## Application by Fosse Green Energy Limited for the Fosse Green Energy

### The Examining Authority's first written questions and requests for information (ExQ2)

Issued on 27 February 2026

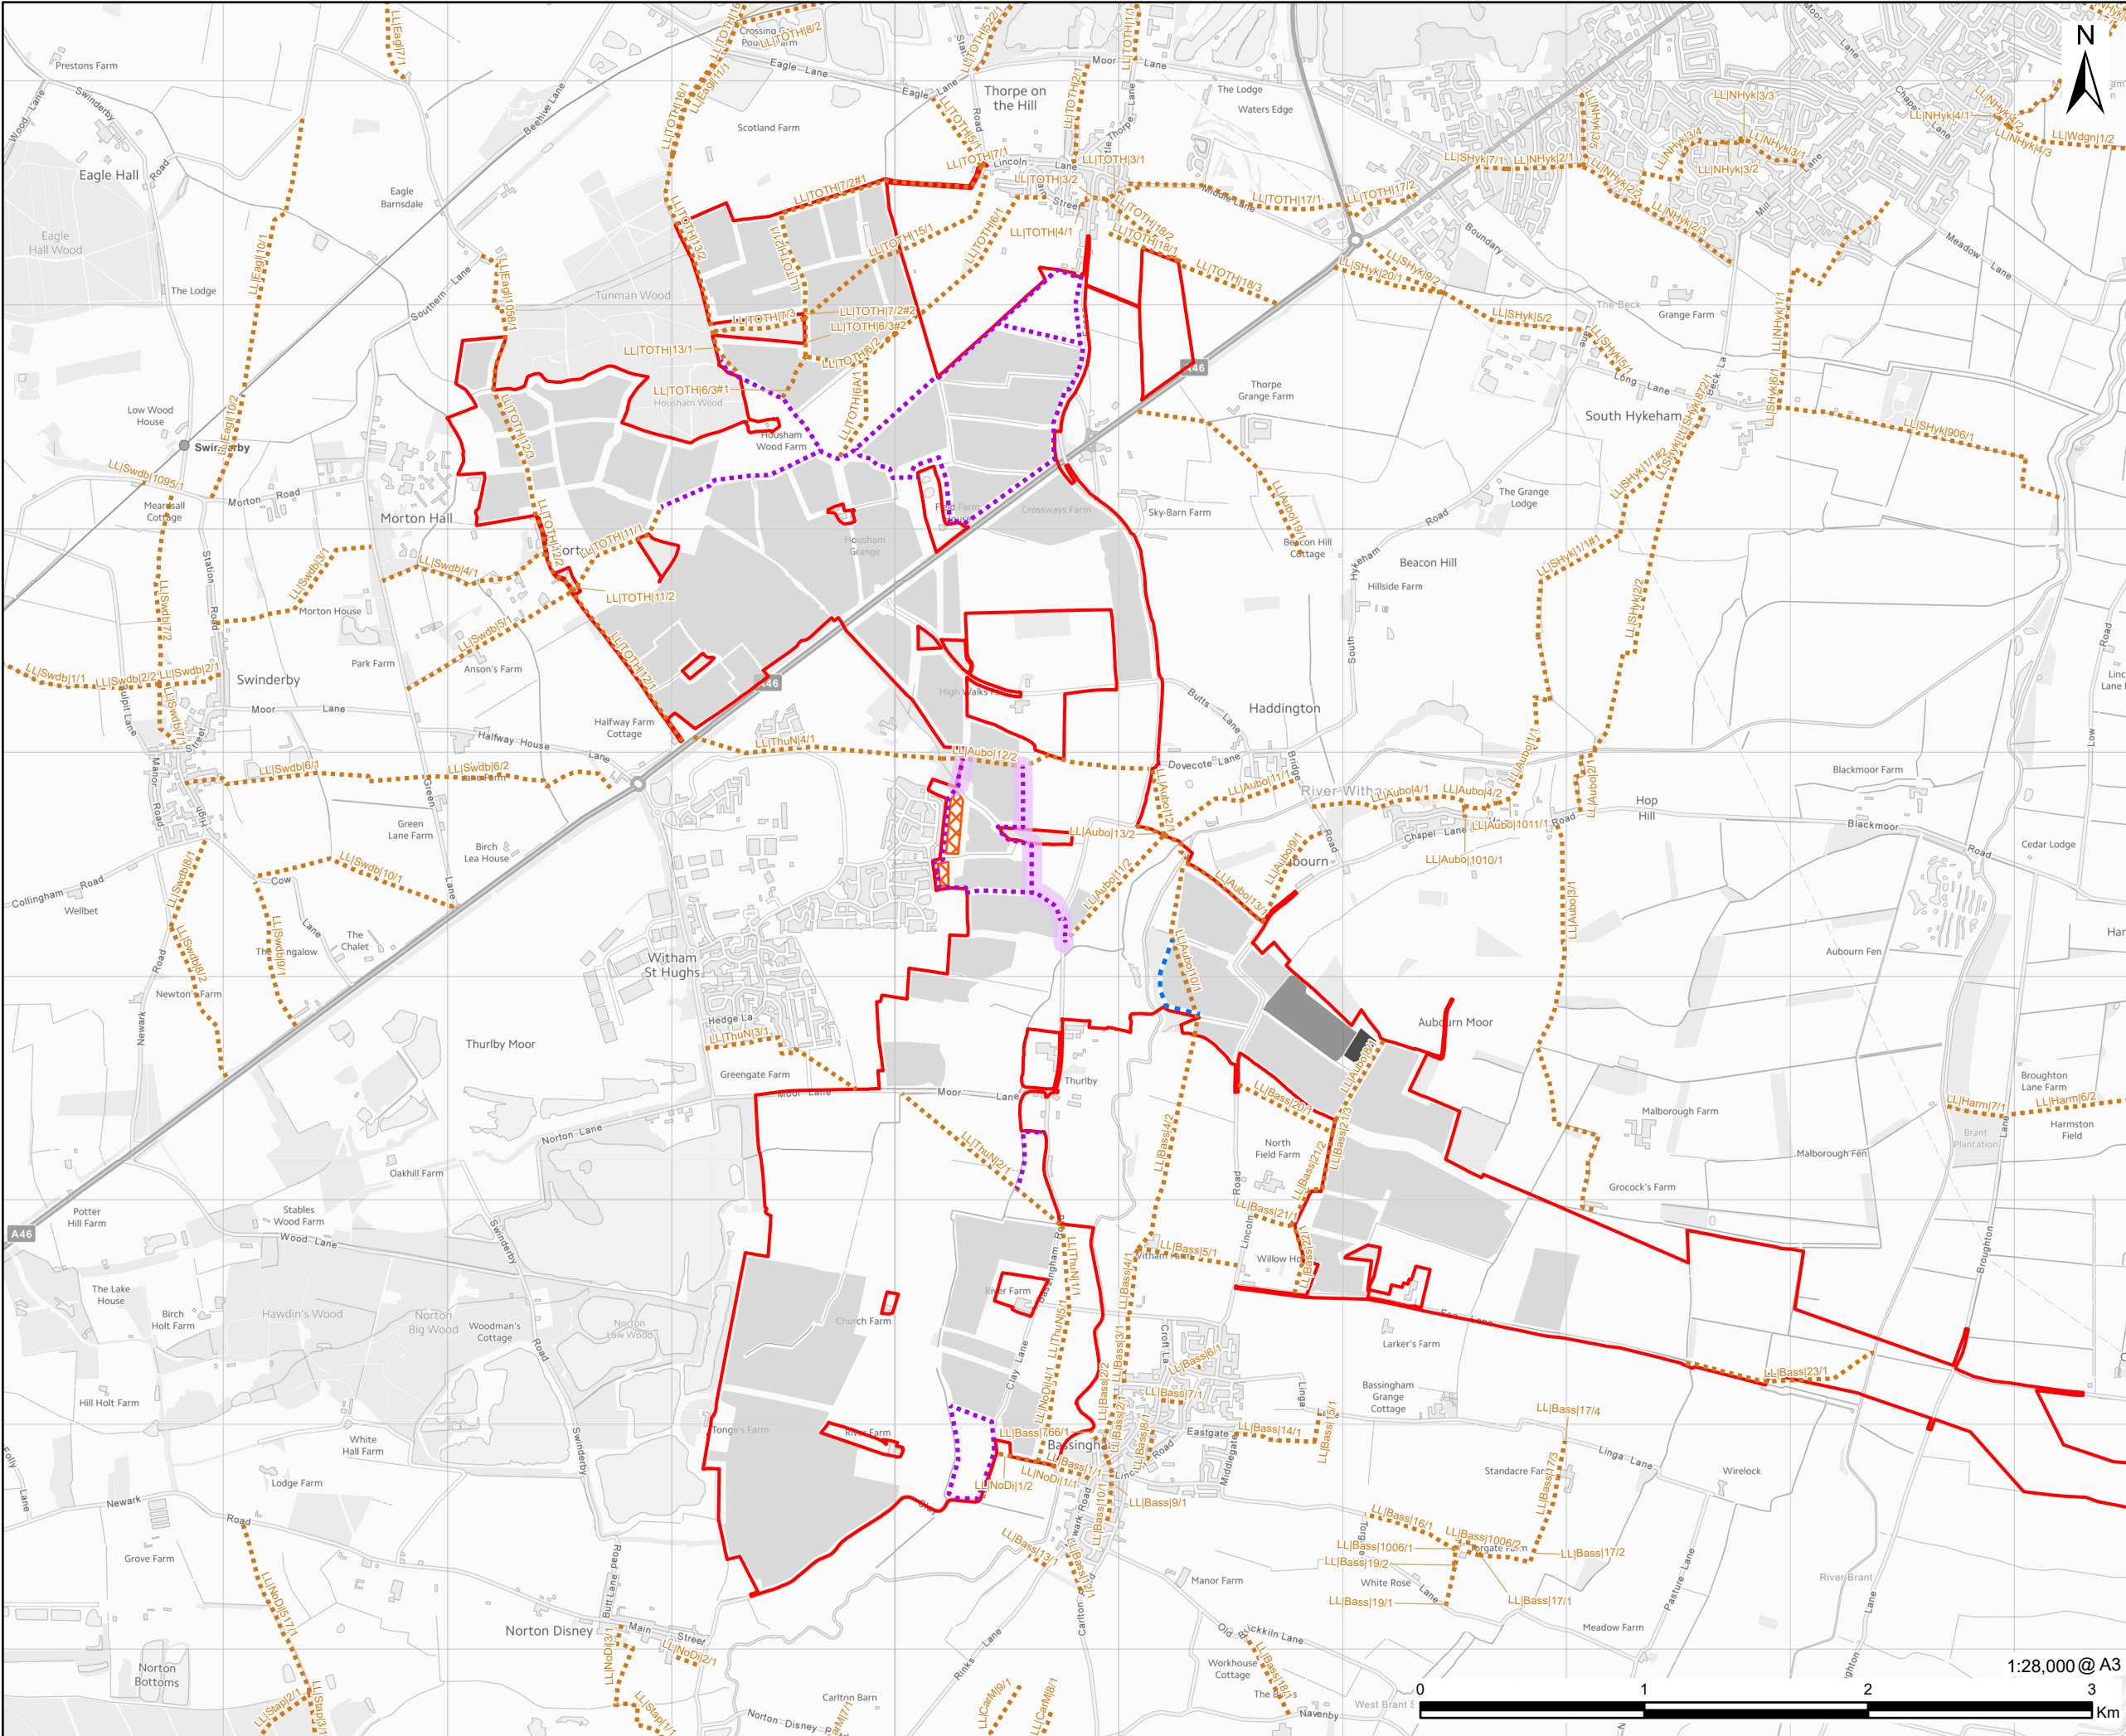
Question Number	Question to:	Question
TT.2.04	Applicant	<p><b>Identification of permissive paths</b></p> <p>Paragraph 12.5.34 in ES Chapter 12 [AS-016] identifies that there are seven existing permissive paths within the proposed Order Limits, namely: 15BCDE, 15BCD1, 17E42A, 15BCD0, 15BCCF, 15BC81 and 15BCC0.</p> <p>In responding to the LIRs [pages 43 and 44 in REP2-031], the applicant states that Figure 3-3: Proposed Permissive Paths [AS-024] identifies “<i>Retained Permissive Paths</i>” (i.e. those already in place) and “<i>Proposed Permissive Paths</i>”. However, based on the key in Figure 3-3, the existing permissive paths and proposed permissive paths to the east of Witham St Hughes seem to cover much of the same lengths. The majority of the lengths with the notation Retained Permissive Paths in Figure 3-3 are identified as “<i>new permissive path</i>” on the Streets, Rights of Way and Access Plans [REP2-004] and on Figure 7.15-1 (sheet 5) of the FLEMP [REP2-021].</p> <p>Clarify the location and status of existing and proposed/new permissive paths within the proposed Order Limits and amend any application plans and other documents where there are any inconsistencies between the status of permissive paths that wholly or partially exist and those that are proposed.</p>
